From: southernwaterplanning [REDACTED]
Sent: 31 October 2019 14:33
To: Planning.Responses <Planning.Responses@arun.gov.uk>
Subject: BN/85/19/DOC: - Land Rear of Lillies Yapton Road, Barnham, PO22 0AY

Your ref
BN/85/19/DOC

Proposal: Approval of details reserved by condition imposed under ref BN/32/15/OUT relating to Condition Nos 6 - proposed surface water drainage, 7 - discharge of any flows to watercourses, 8 - SUDs system, 9 - future access & maintenance of any watercourse or culvert, 10 - surface water drainage, 11 - rising main & foul sewer and 15 - foul drainage system.

Site: BN/85/19/DOC: - Land Rear of Lillies Yapton Road, Barnham, PO22 0AY.

REV	DESCRIPTION	DRN	CHD	DATE	
☒	PRELIMINARY	☐	INFORMATION	☐	TENDER
☐	CONSTRUCTION	☐	AS BUILT		
SCALE	1:500 @ A2	DATE	JULY 2019		
DRAWN	CLS	CHK	JGF		
DRAWING NO.	17748-BARN-5-508	REV	-		
TITLE	YAPTON ROAD BARNHAM				
DETAILS	S104 General Arrangement

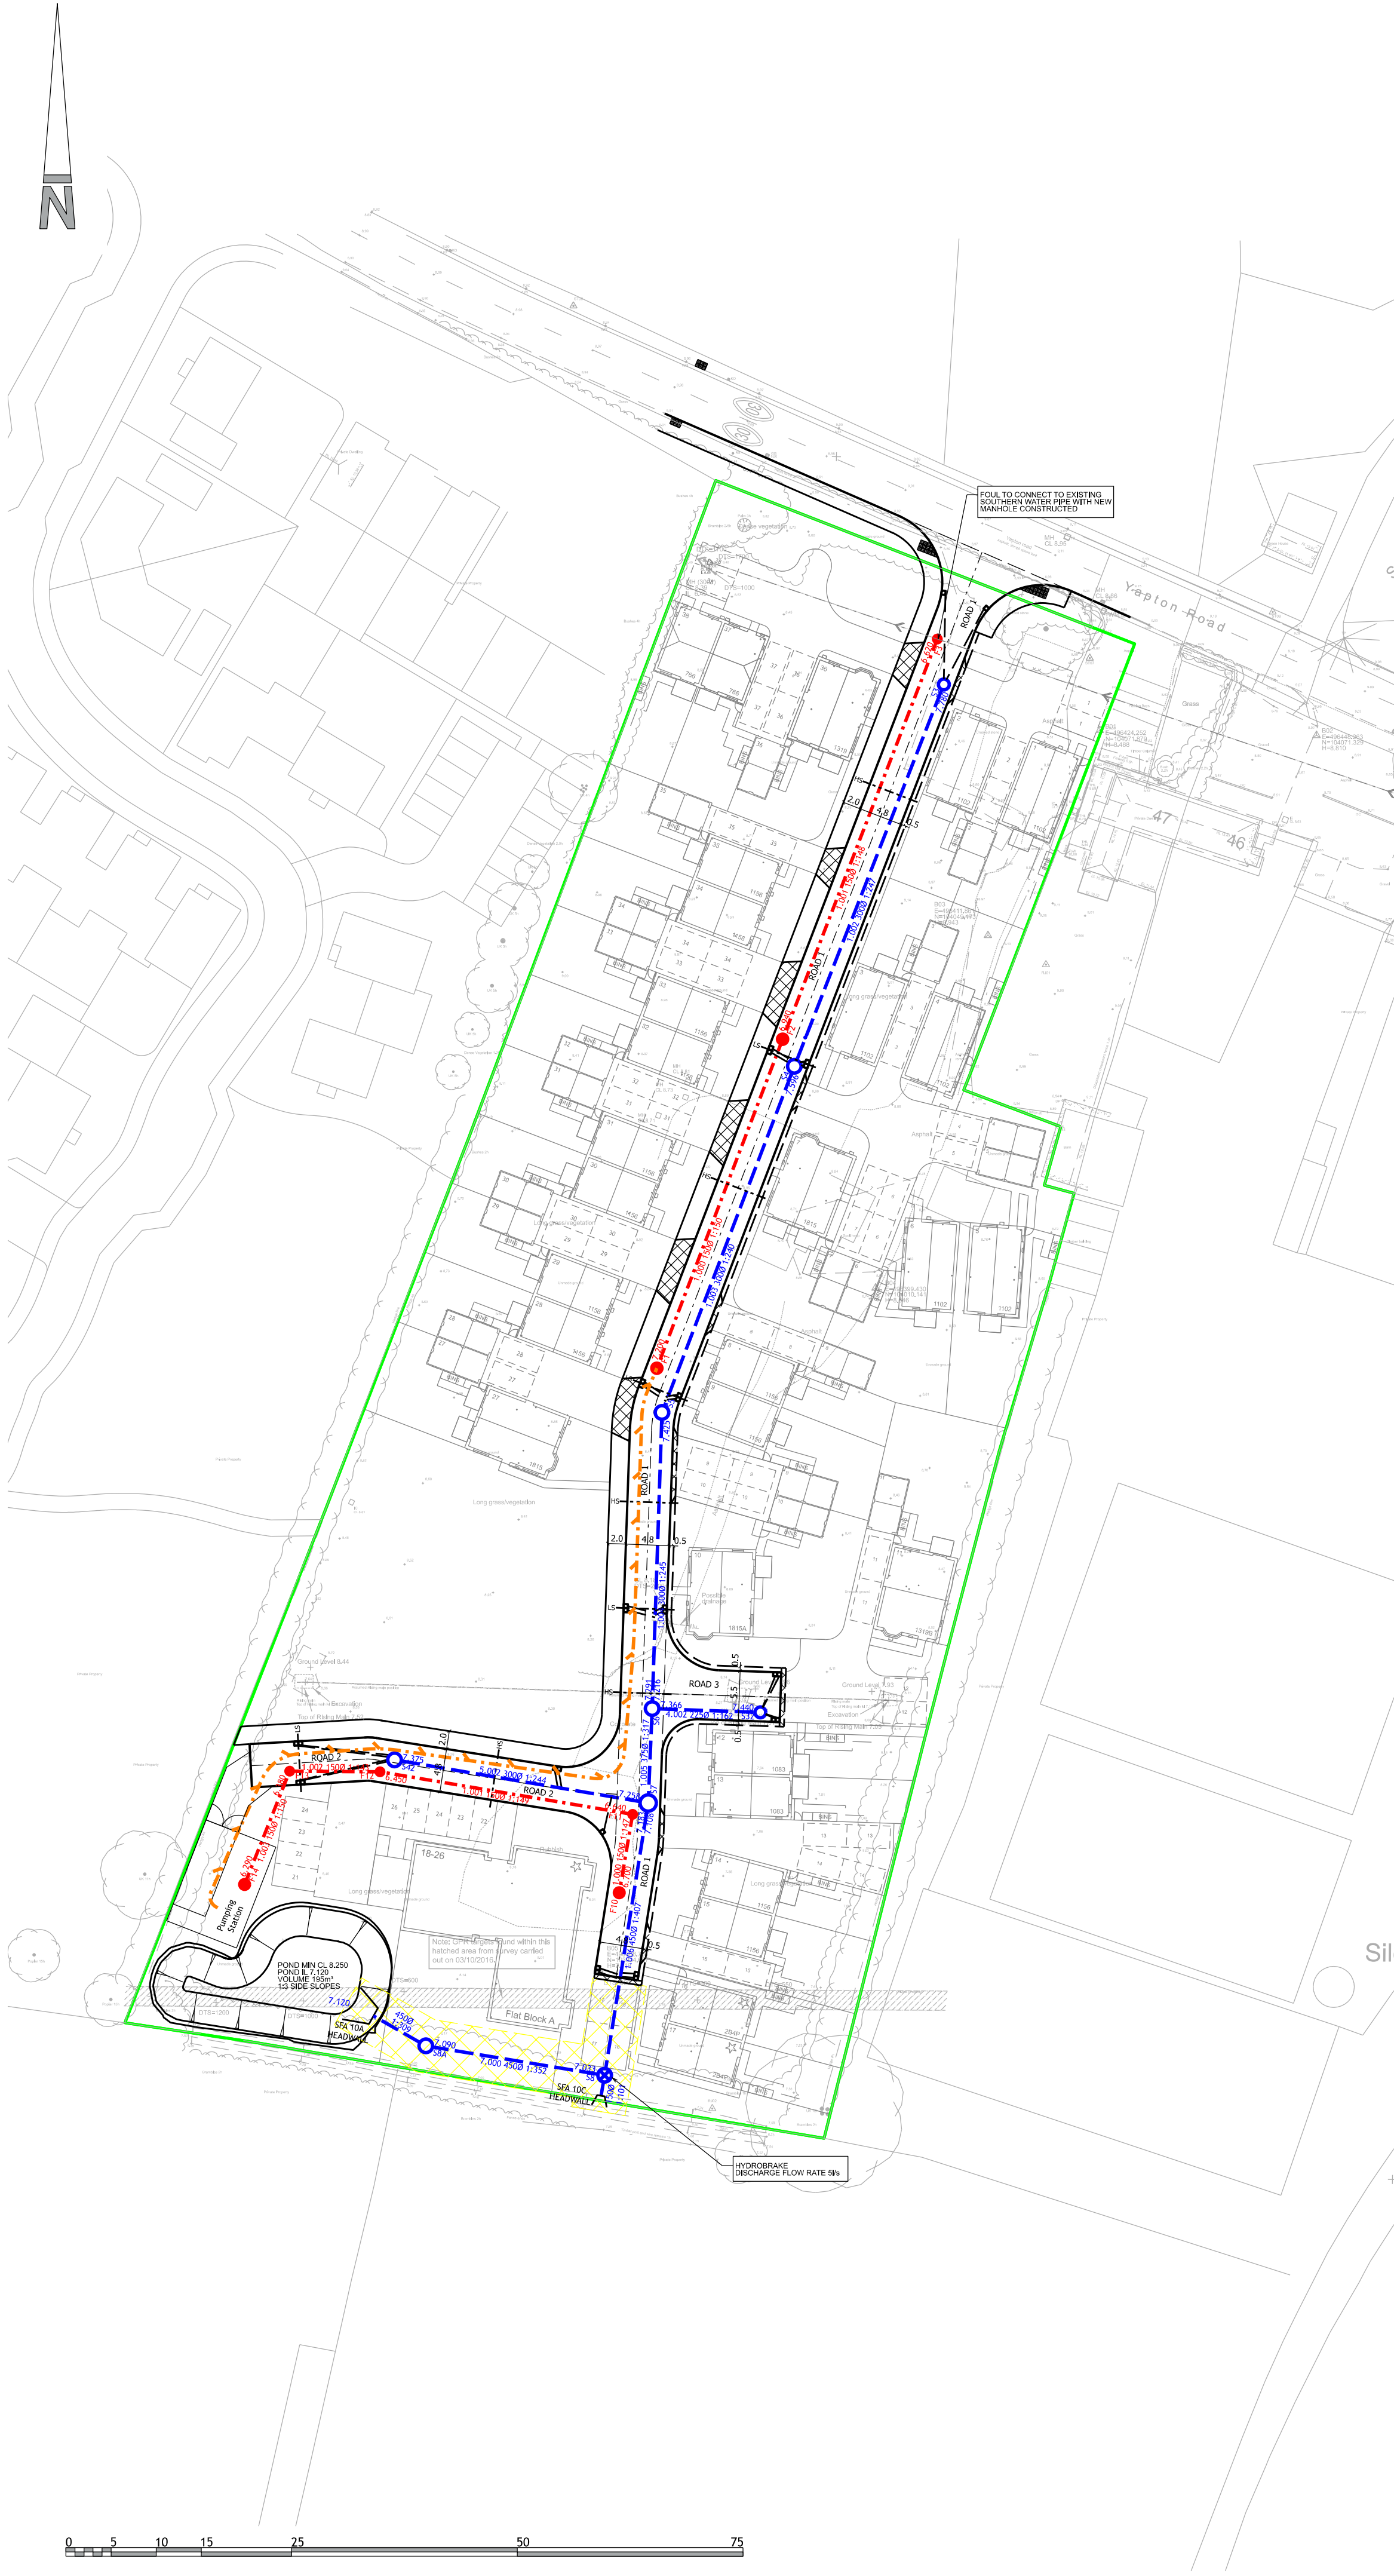
Southern Water cannot recommend discharge of condition 6, 8, 10 and 11. Southern Water would not accept construction of permeable paving over or within 5 metres of the public sewers. The design of drainage should ensure that no land drainage or groundwater is to enter public sewers network.

In order to assess the impact of the proposed surface water drainage, construction details of permeable paving should be provided demonstrating that the above can be met.
